**City of Portland, Maine - Building or Use Permit Application**  
 389 Congress Street, 04101 Tel: (207) 874-8703, Fax: (207) 874-8716

<b>Permit No:</b> 06-0213	<b>Issue Date:</b>	<b>CBL:</b> 032 V014001
------------------------------	--------------------	----------------------------

<b>Past Use:</b> Commercial	<b>Proposed Use:</b> Commercial Install Kitchen Hood Exhaust System	<b>Permit Fee:</b> \$156.00	<b>Cost of Work:</b> \$15,000.00	<b>CEO District:</b> 1
<b>Proposed Project Description:</b> Install a Kitchen Hood Exhaust System		<b>FIRE DEPT:</b> <input type="checkbox"/> Approved <input type="checkbox"/> Denied	<b>INSPECTION:</b> Use Group: Type	
		Signature:	Signature:	
<b>PEDESTRIAN ACTIVITIES DISTRICT (P.A.D.)</b>				
Action <input type="checkbox"/> Approved <input type="checkbox"/> Approved w/Condition <input type="checkbox"/> Denied				
		Signature:	Date:

Kitchen Hood System Procedure to Hang From Ceiling

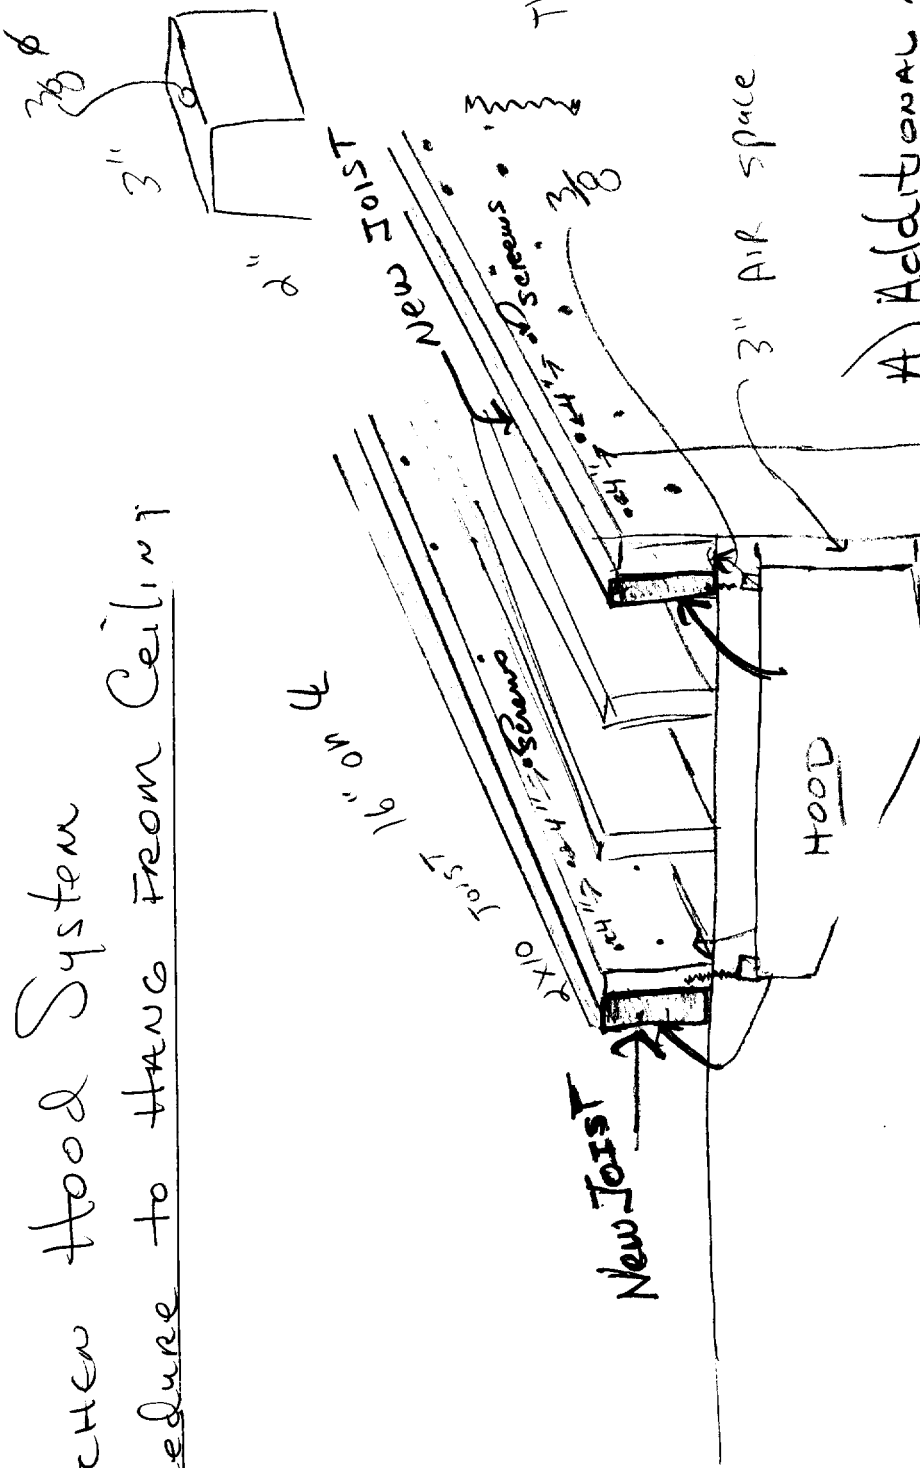
**Comments:**  
3/8/2006-mjn: Need some structural info Left message w Archie Giobbi and Tigpro
